**ANGEL PLACE
LEVEL 8, 123 PITT STREET
SYDNEY NSW 2000**

11 July 2022

AMENDMENT TO SSD-10272349 YIRIBANA LOGISTICS ESTATE

DRAWING	DOCUMENT TITLE
MP 00	Location Plan / Cover sheet
MP 01	SSDA Masterplan
MP 02	Estate Works Staging Plan
MP 03	Subdivision Plan
MP 04	Site Analysis Plan
MP 05	Zoning Plan
MP 06	Signage Plan
MP 07	Fire Protection Plan
MP 08	Vegetation Management Plan
MP 09	Fencing Management Plan

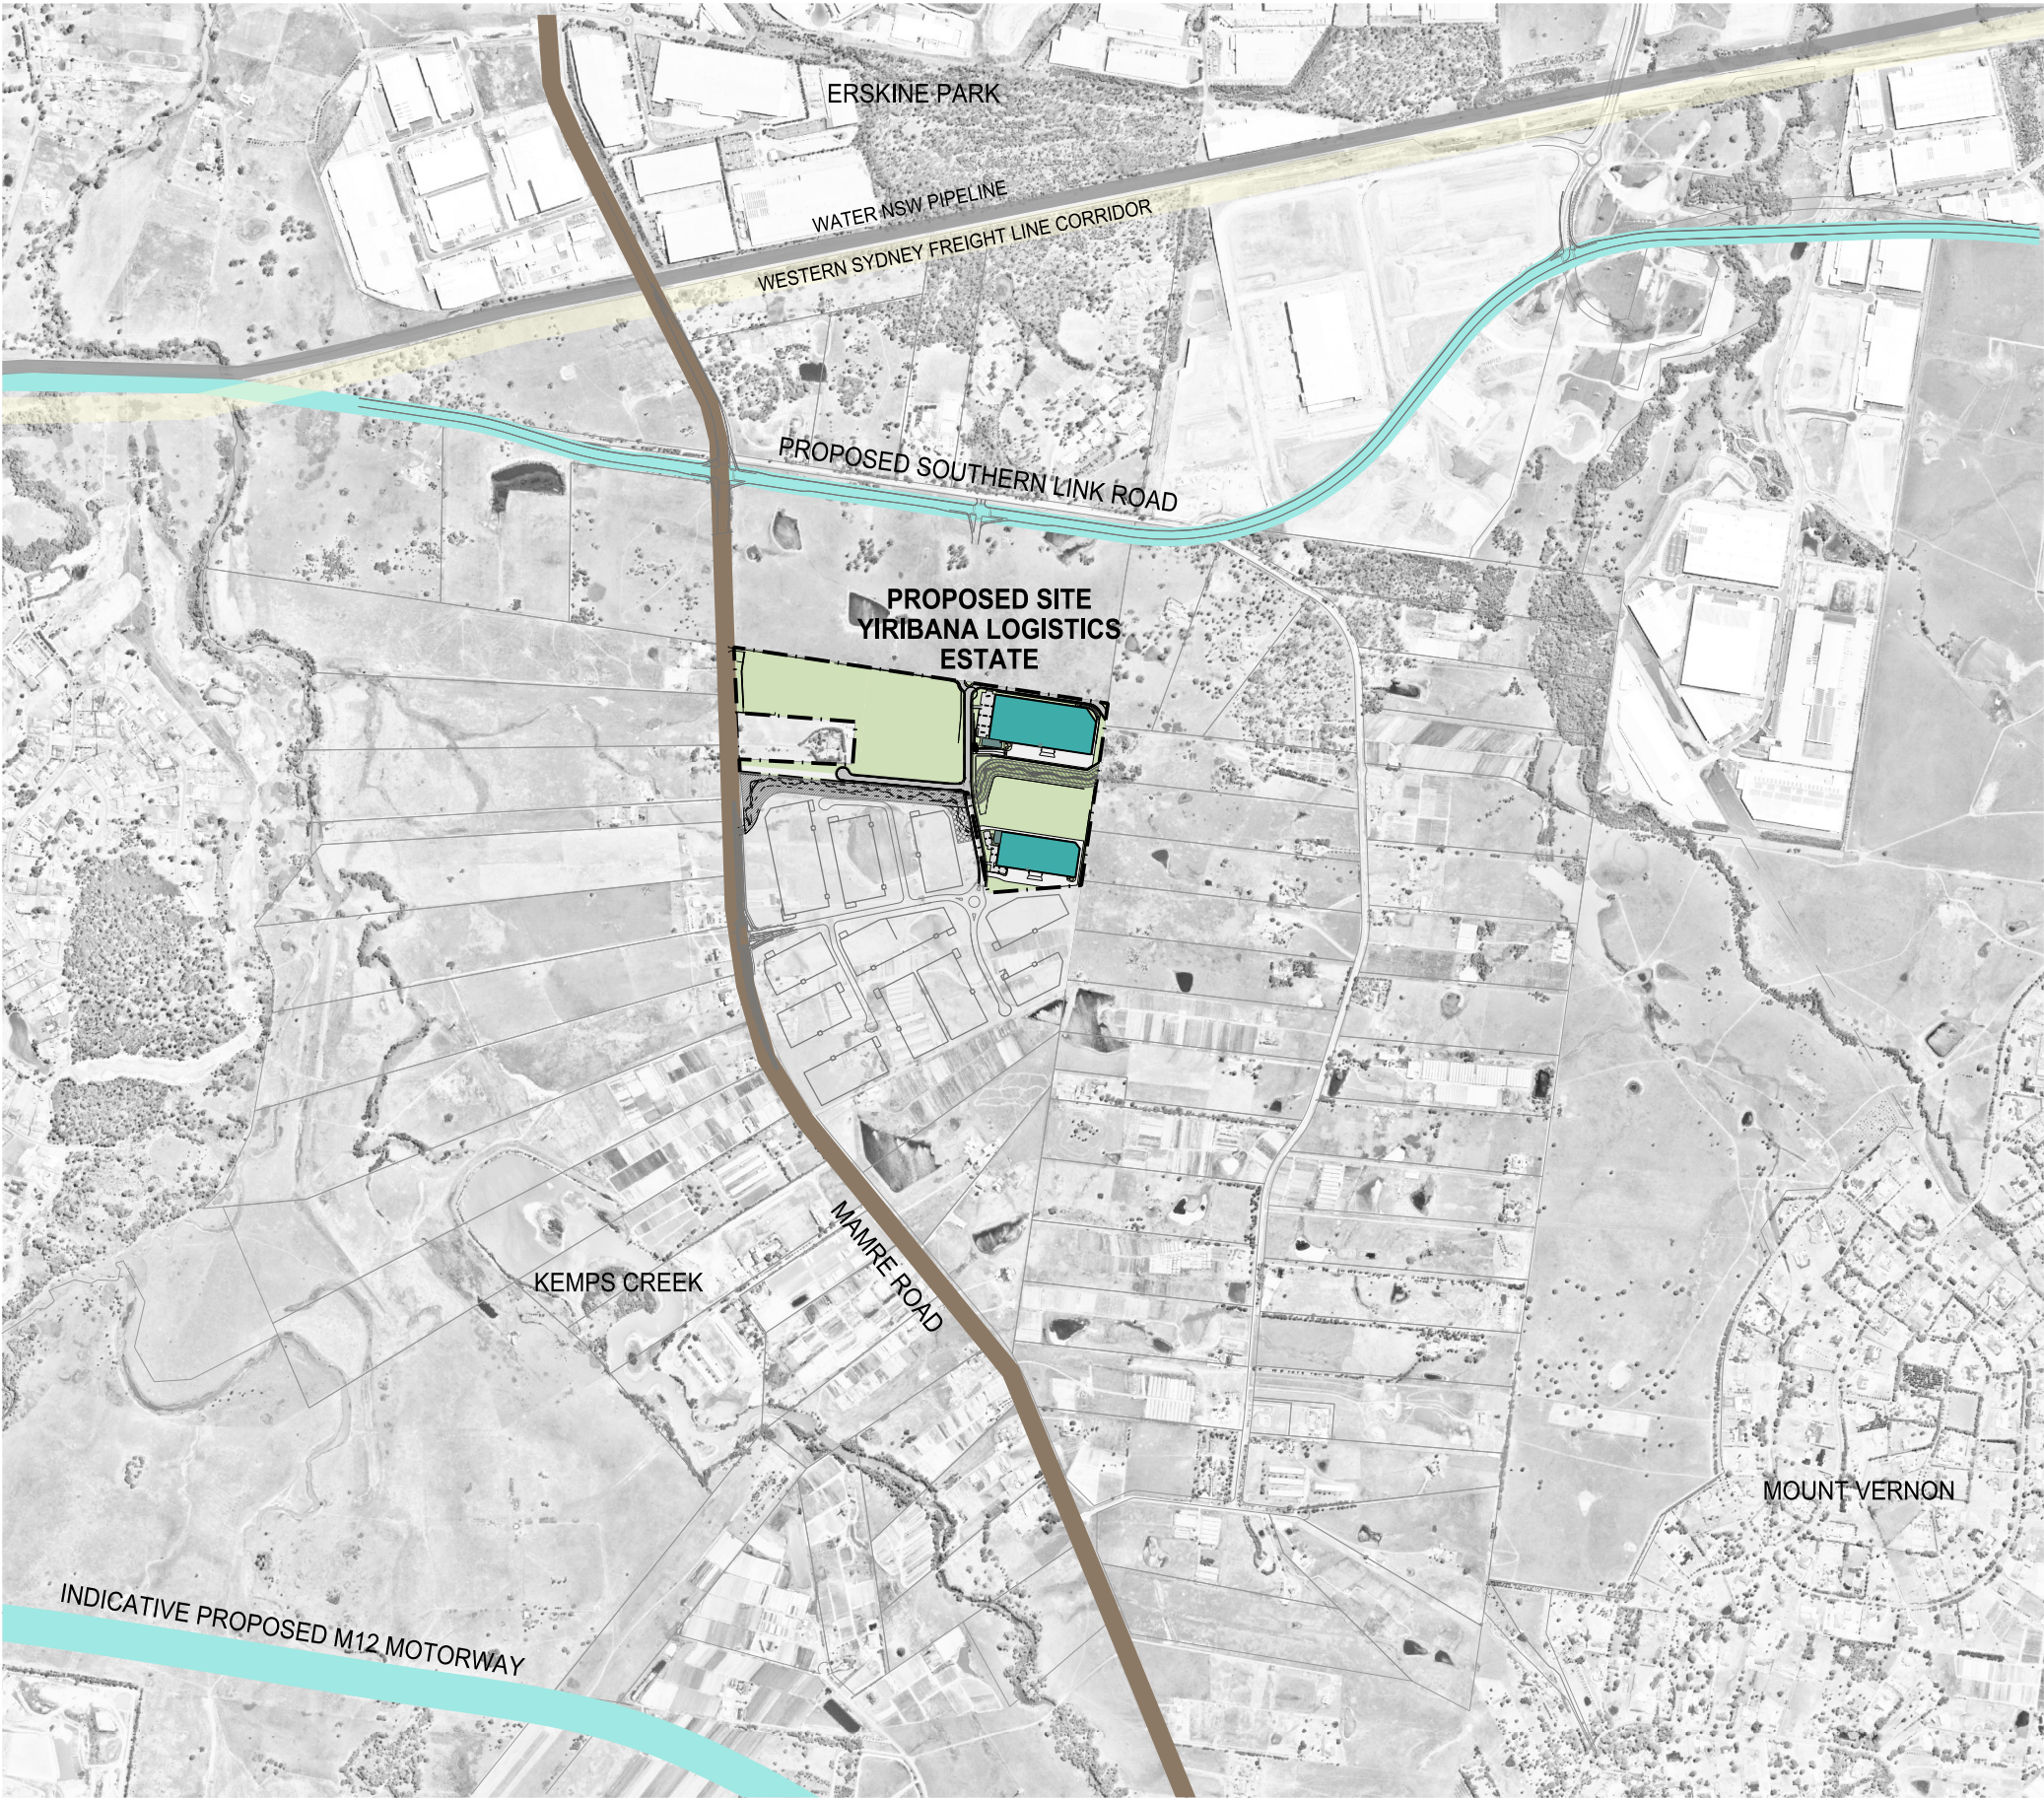
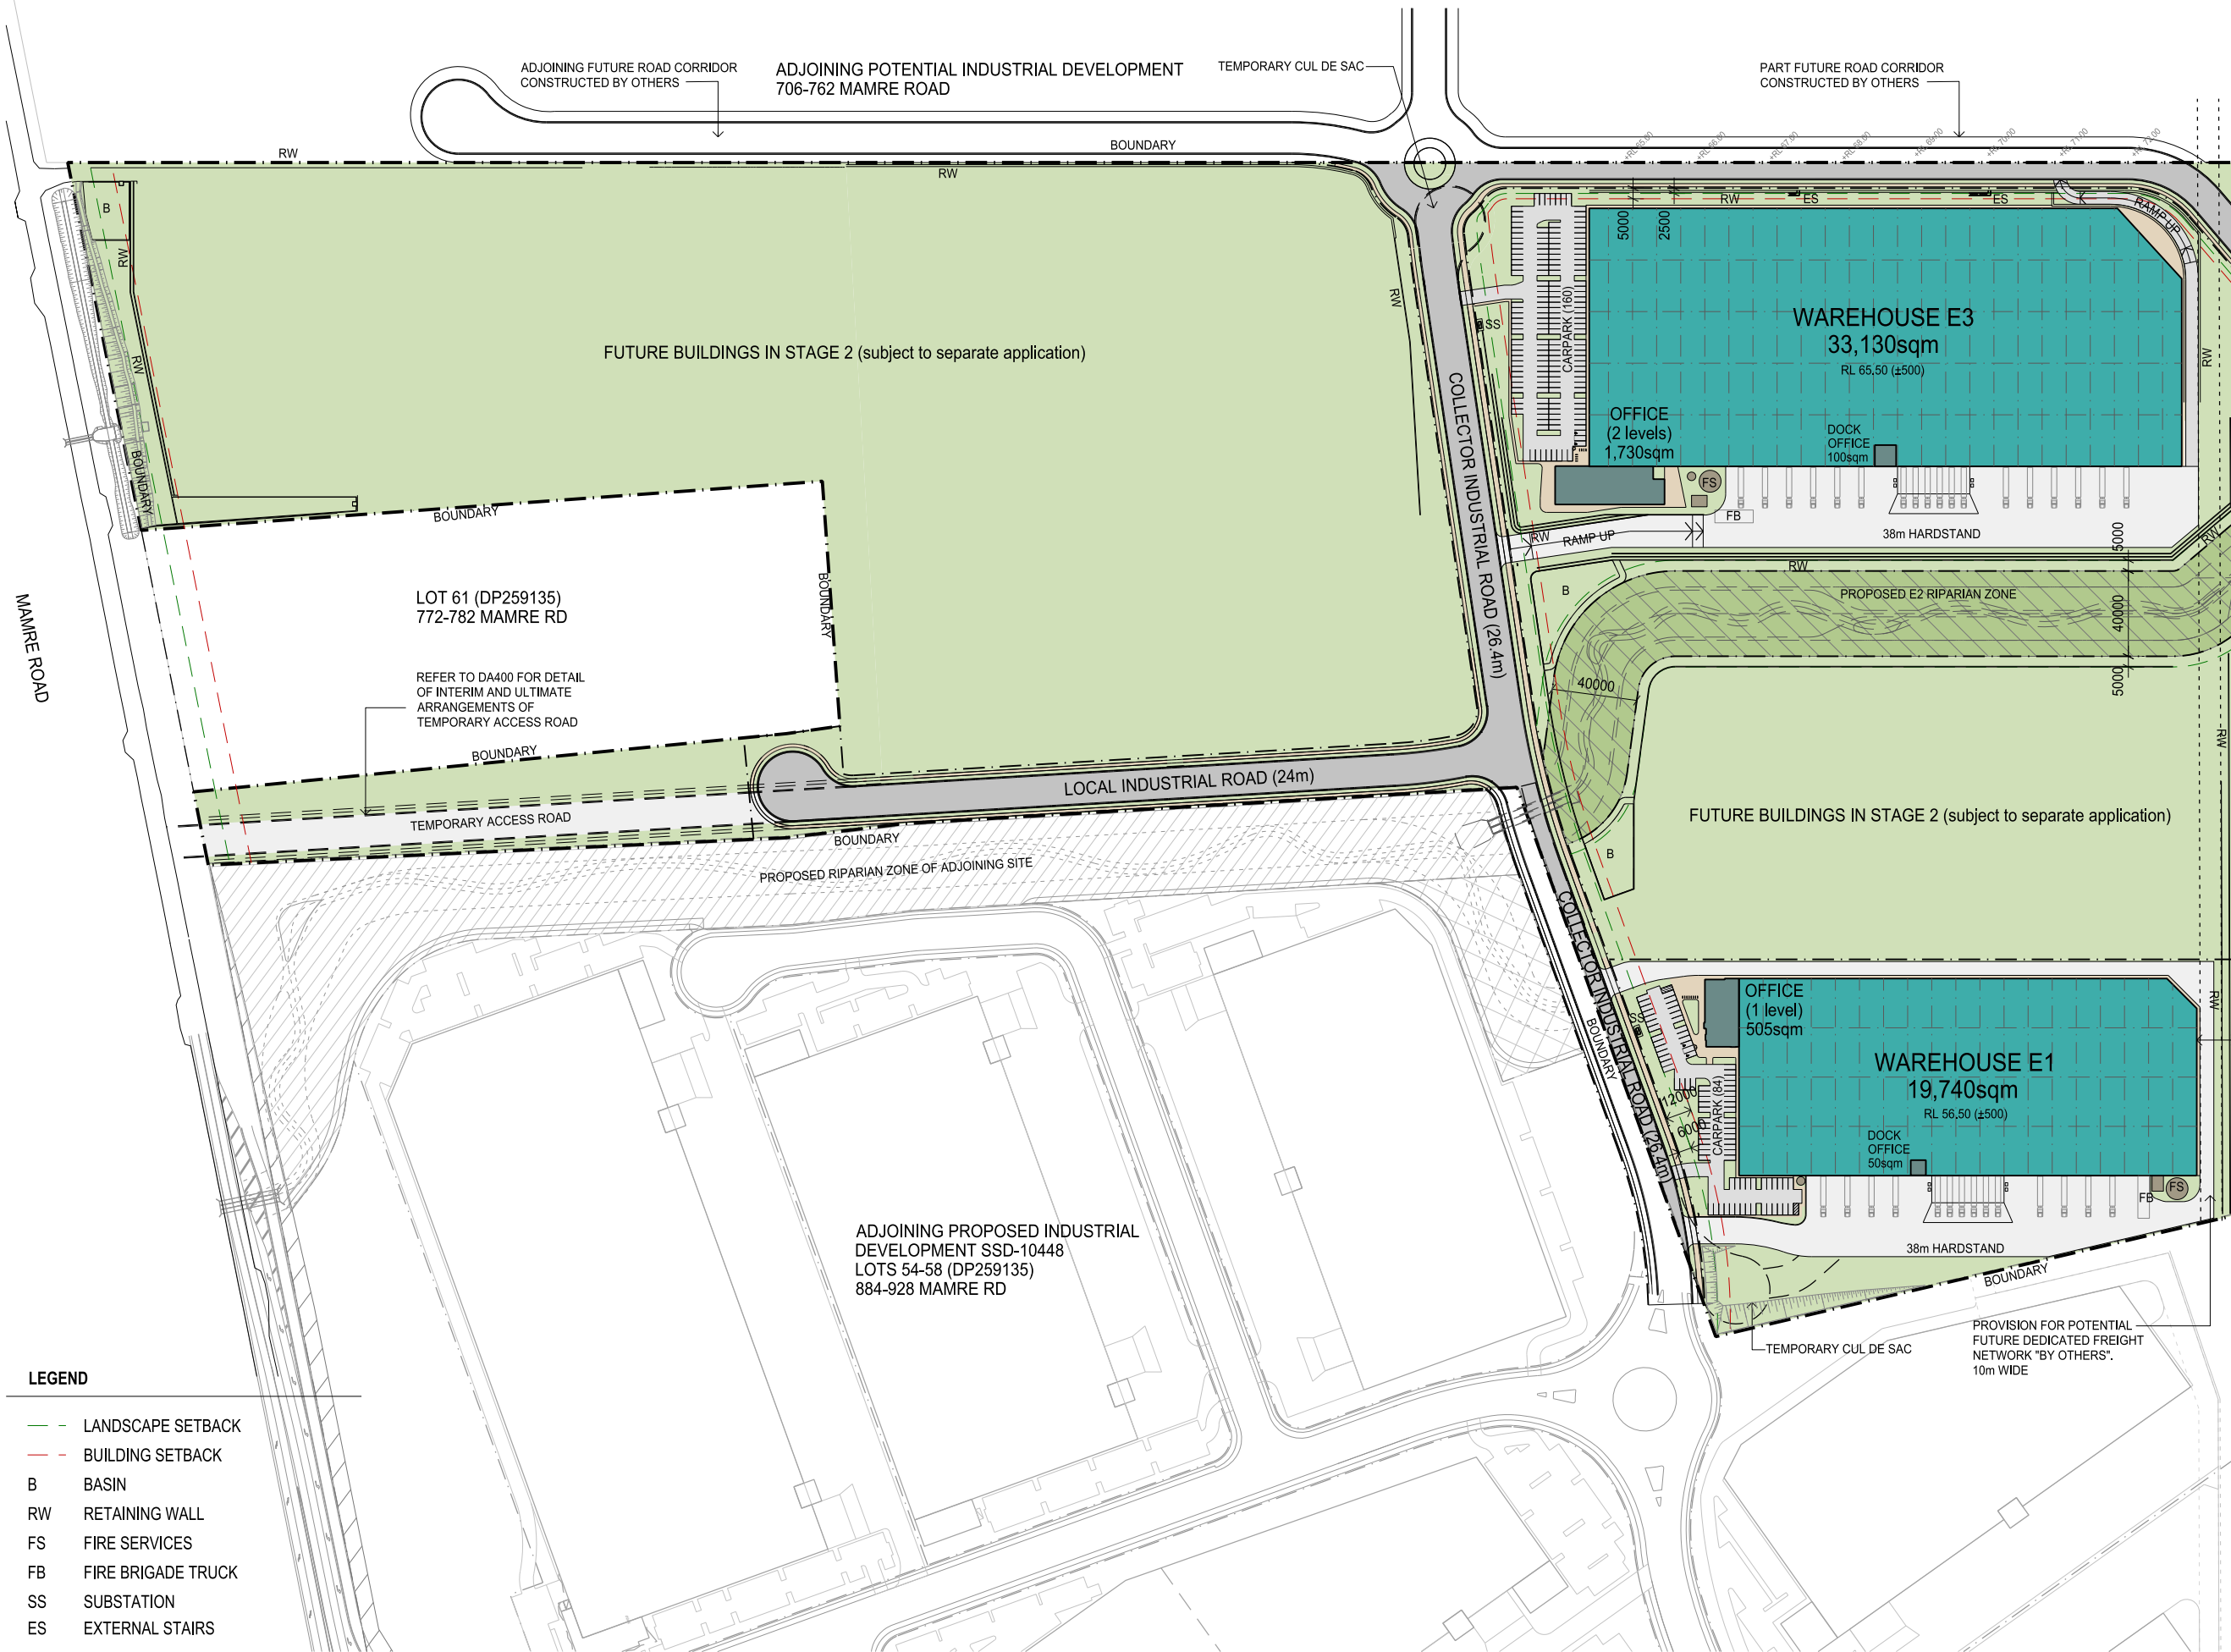
The amendment to SSD-10272349 is for the withdrawal of the Concept Master Plan from the application, with only the Stage 1 development (now referred to as the '**Site Layout Plan**') works to remain. The Concept Master Plan comprised a total of five (5) warehouses, three (3) of which (warehouse 2, 4 and 5) were proposed for concept approval and two (2) (warehouses 1 and 3) for Stage 1 approval.

- ~~* A Concept Master Plan comprising five (5) industrial warehouses and ancillary offices, internal road network, 35m environmental corridor, building locations, GFA, setbacks, car parking and built form parameters.~~
- **Detailed development consent for:**
 - ~~— Subdivision;~~
 - ~~— Site-wide preparation works including estate-wide clearing of all vegetation and dam-dewatering;~~

- Realignment of existing E2 zone with a maintained width of 40m, with landscaping and planting in accordance with a Vegetation Management Plan.
 - On-site bulk earthworks including any required ground dewatering.
